PROJECT TITLE: Toodnow Res.	ZONE MAP/DRG. FILE # D.22 00/
DRB#: EPC#:	WORK ORDER#:
LEGAL DESCRIPTION: LOT 19, BIK. 20, 7	2, 42 N. A/bus 4 cres
CITY ADDRESS:	
CIT I ADDICEOU.	
ENGINEERING FIRM CONSULTING En	gineers CONTACT: Phil
	PHONE: 281-2444
ADDRESS:	TP CODE:
CITY, STATE Edgewood, New Mexico 8701	· · · · · · · · · · · · · · · · · · ·
The state of the s	CONTACT:
<u></u>	PHONE:
ADDRESS:	ZIP CODE:
CITY, STATE:	
ARCHITECT:	CONTACT:
ARCHIECI. ADDRESS:	PHONE:
CITY, STATE:	ZIP CODE:
CILI, OIIXID.	
SURVEYOR:	CONTACT:
ADDRESS:	PHONE:
CITY, STATE:	ZIP CODE:
CILI, OIMIL.	
CONTRACTOR:	CONTACT:
ADDRESS:	PHONE:
CITY, STATE:	ZIP CODE:
CALLY CALLADA	• •
TYPE OF SUBMITTAL:	K TYPE OF APPROVAL SOUGHT:
DRAINAGE REPORT	SIA/FINANCIAL GUARANTEE RELEASE
DRAINAGE PLAN 1st SUBMITTAL	PRELIMINARY PLAT APPROVAL
X DRAINAGE PLAN RESUBMITTAL	S. DEV. PLAN FOR SUB'D APPROVAL
CONCEPTUAL G & D PLAN	S. DEV. FOR BLDG. PERMIT APPROVAL
GRADING PLAN	SECTOR PLAN APPROVAL

Subject: RE: City Hydrology Letter For the Grading and Drainage Plan for 11301 San Antonio (D22/D001),

Re: Lot 19, Block 20, Tract 2, Unit 2, North Albuquerque Acres 11301 San Antonio Dr. NE Grading and Drainage Plan Engineer's Stamp dated 6-07-13 (D2

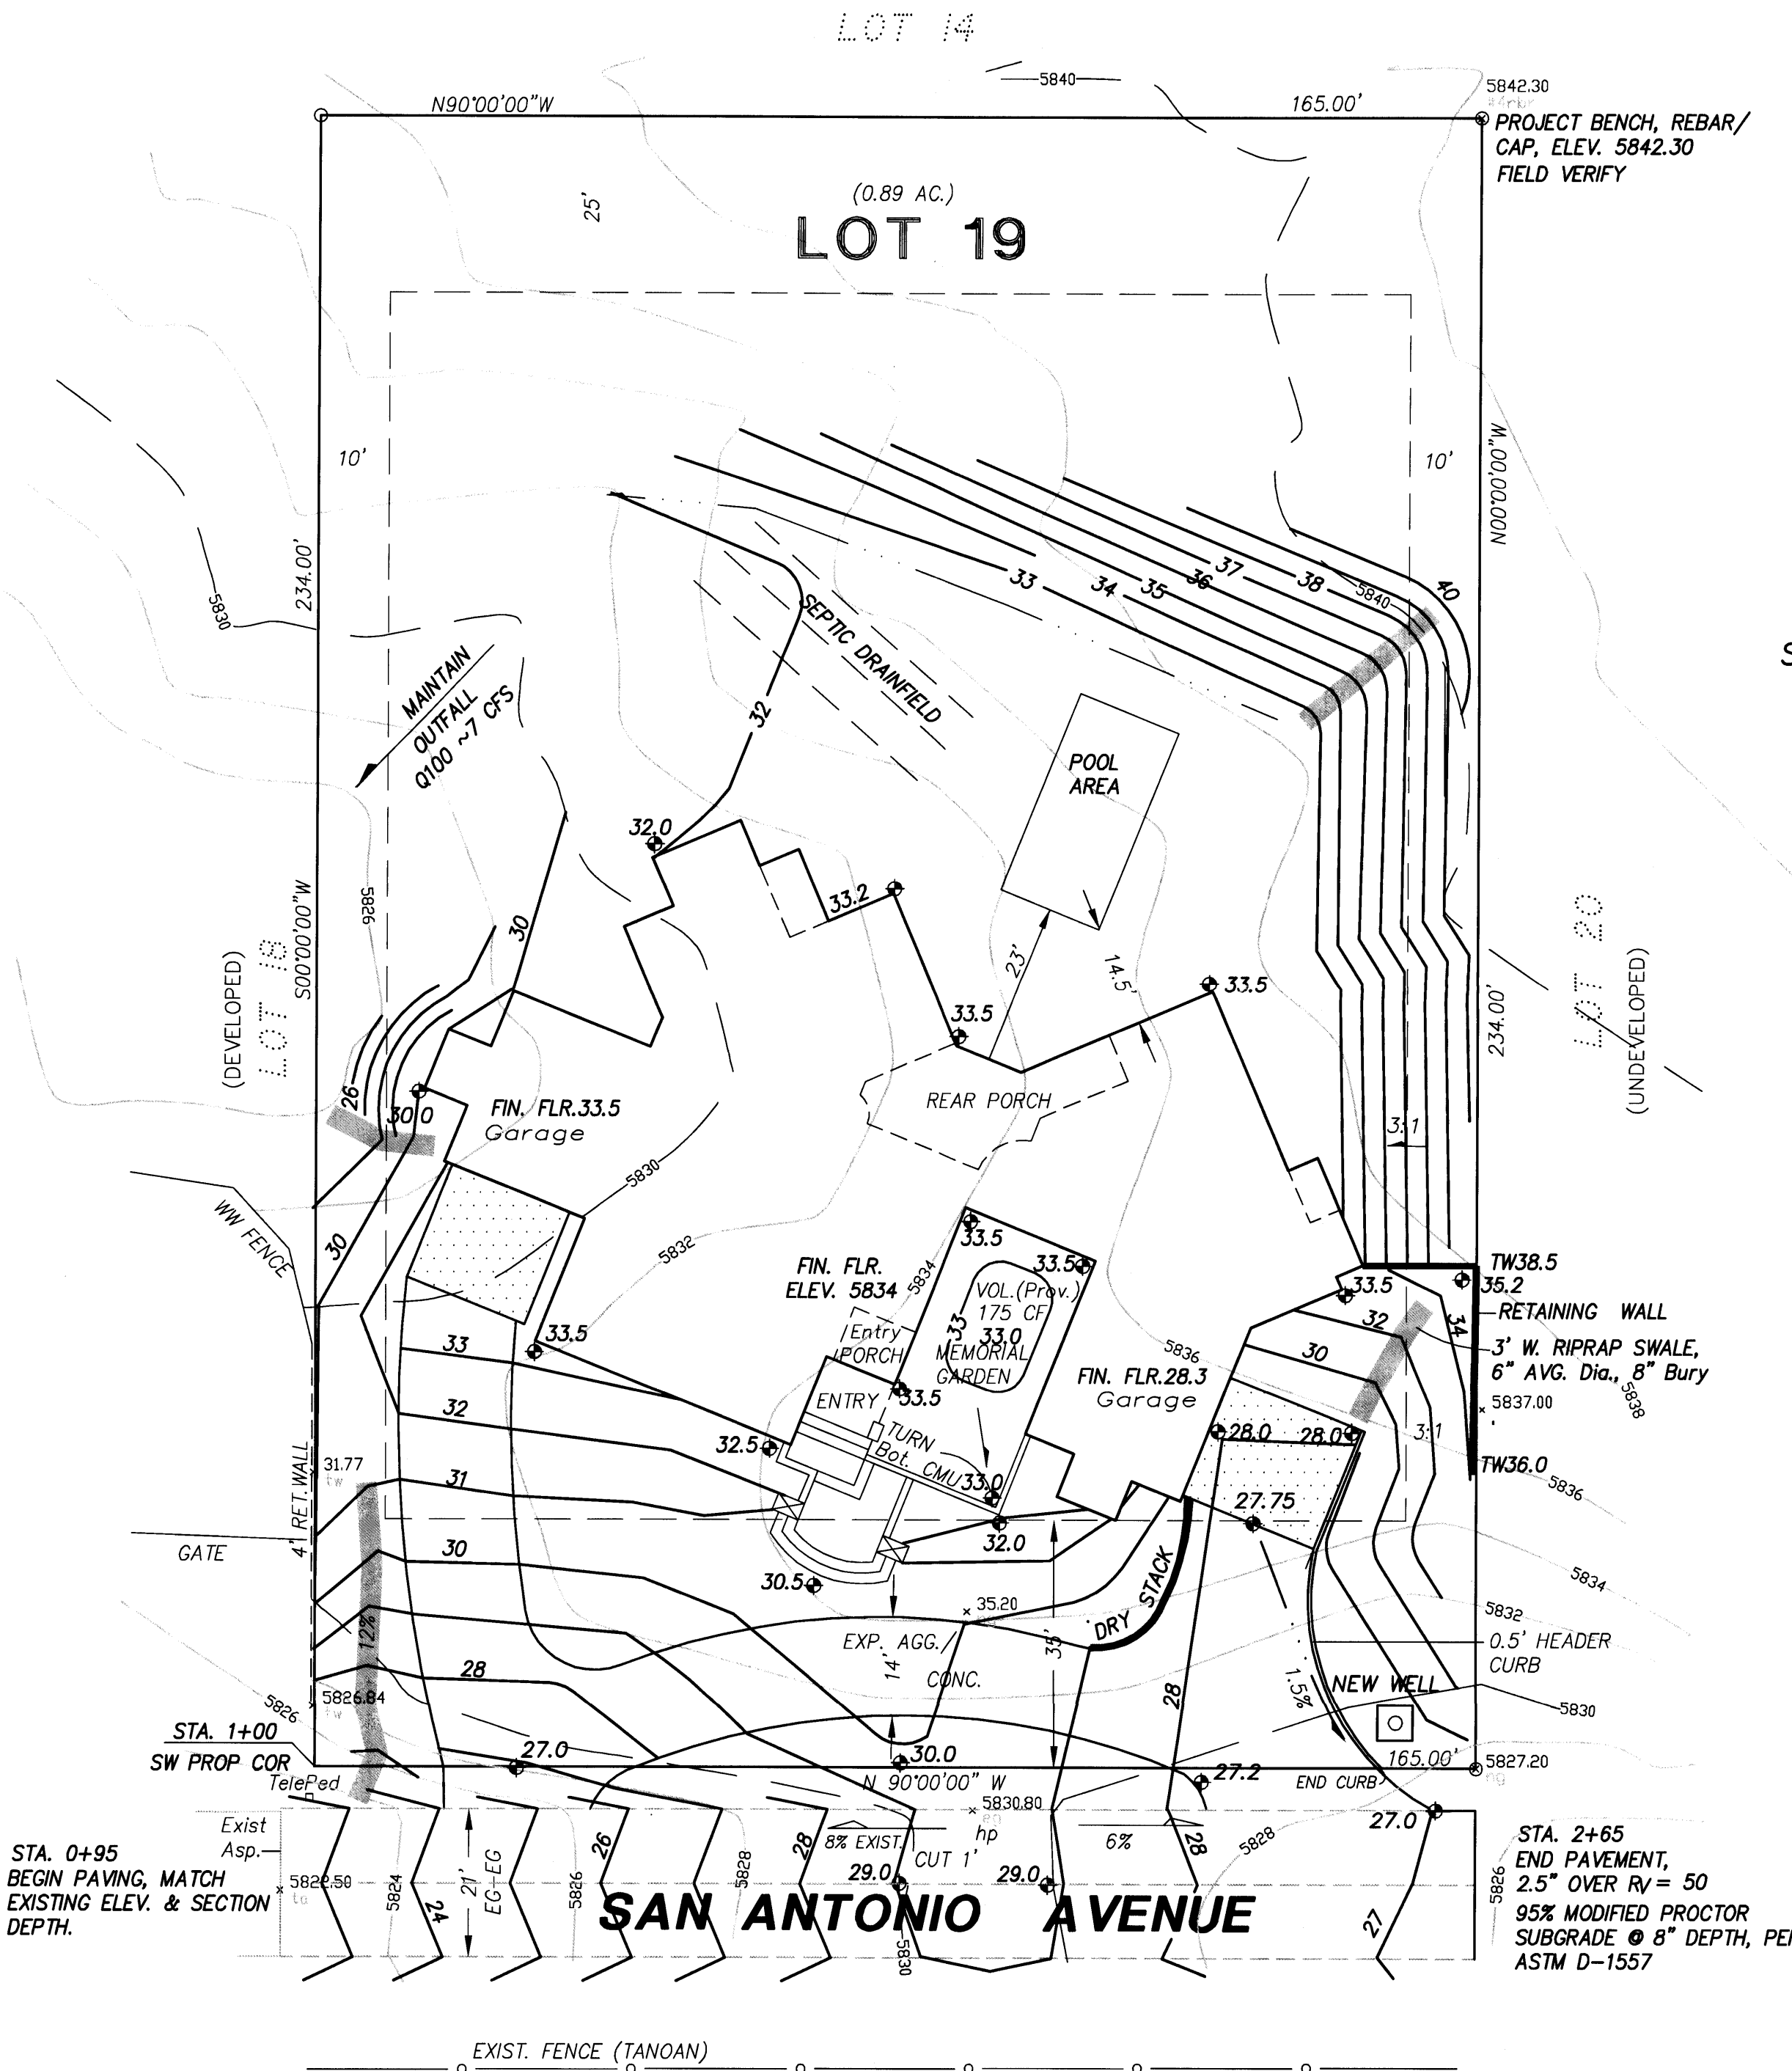
• Any work on San Antonio should be submitted and approved through Design Review Committee (DRC) and constructed through the work order process. The driveways must be constructed under the work order. Curb and gutter and sidewalk may be required.

• In most cases the entire site is disturbed as part of clearing and grubbing. Therefore, under the developed conditions Treatment A=0%.

- Please double check the "D" treatment. It appears that the D treatment is more than 27%. Clearly show all the concrete work around the pool area and other walkways.
- It is not clear how and how much runoff will drain to the proposed detention pond. Show the 4" pipe.
- A desilting pond may be required at the east end of the San Antonio Dr.

How will the septic system be accessed? A retaining wall may have to be constructed along the westerly boundary to create the necessary access to the back. Mr. Clark, July 9, 2013 Page 2

- 7 cfs is shown to drain to Lot 18. Does this flow include the developed runoff from the back of the house? We recommend that the 7 cfs to be routed south to San Antonio. Provide more spot elevation around the pool area and the back of the house. Provide an offsite drainage basin and calculations.
- Total disturbed area included the road work will be more than one acre. Therefore, SWPPP will be required.

1) Please provide FEMA Flood Insurance Rate Map the shows the relationship of the proerty to the nearest flood zone.

2) Indicate on the plan the the driveway access points are to be constructed as per Standard Drawing 201012.

3) Plan must show adequate basin area to provide required detention volume to memorial garden. Pond volume calculation assumes the whole site runs through the detention pond.

4) Show pond discharge pipe and associated inverts on the plan.

5) Indicate the 33 contour location in backyard.

1st bullet - Work Order for San Antonio, I spoke with Moncia O. and according to her the two neighbors to our west were not required to go to Work Order. As discussed with you, this may be that the non-st'd roadway was extended as temporary - 21-22' paved width, without curb/gutter nor sidewalk, within a non-standard Right-of-Way (measured 43 feet) from the north R.O.W. to the Tanoan improvements (permanent-type fencing).

- 2/8 The plan shows 1/4 of the 0.88 lot remaining undisturbed, and is not to be stripped of natural vegetation during clear/grub operations. Additionally, please note that any soil disturbed must be revegetated to City spec. 1011 per note 4. A SWPPP, therefore should not be required.

- 3 I checked the 27%(D) and it calced correctly The pool and deck has been deleted.
- 4 The pond calcs are clarified, and will spill out the Turned CMU (equiv. alternate to 4" pipe)

- 5 A small, appropriately sized desilting pond could be incorporated during construction although is not recommended.
- 6 Septic Access According to Alpha Septic, an intermediate pump is/can be employed in longer runs for maintenance operations.

- 7 Upstream basin calculation is verified/reduced in the calcs section + see plan upper left corner. As discussed this plan is within the previous overall study provided by RTLto the County back in 1999. Maintaining historic flow paths are preferred in the County. From my experience, even slight diversions as you suggested should be discouraged. The current County review fee in NAA is 220\$ and continues to pay for/reimburses the cost of this study.
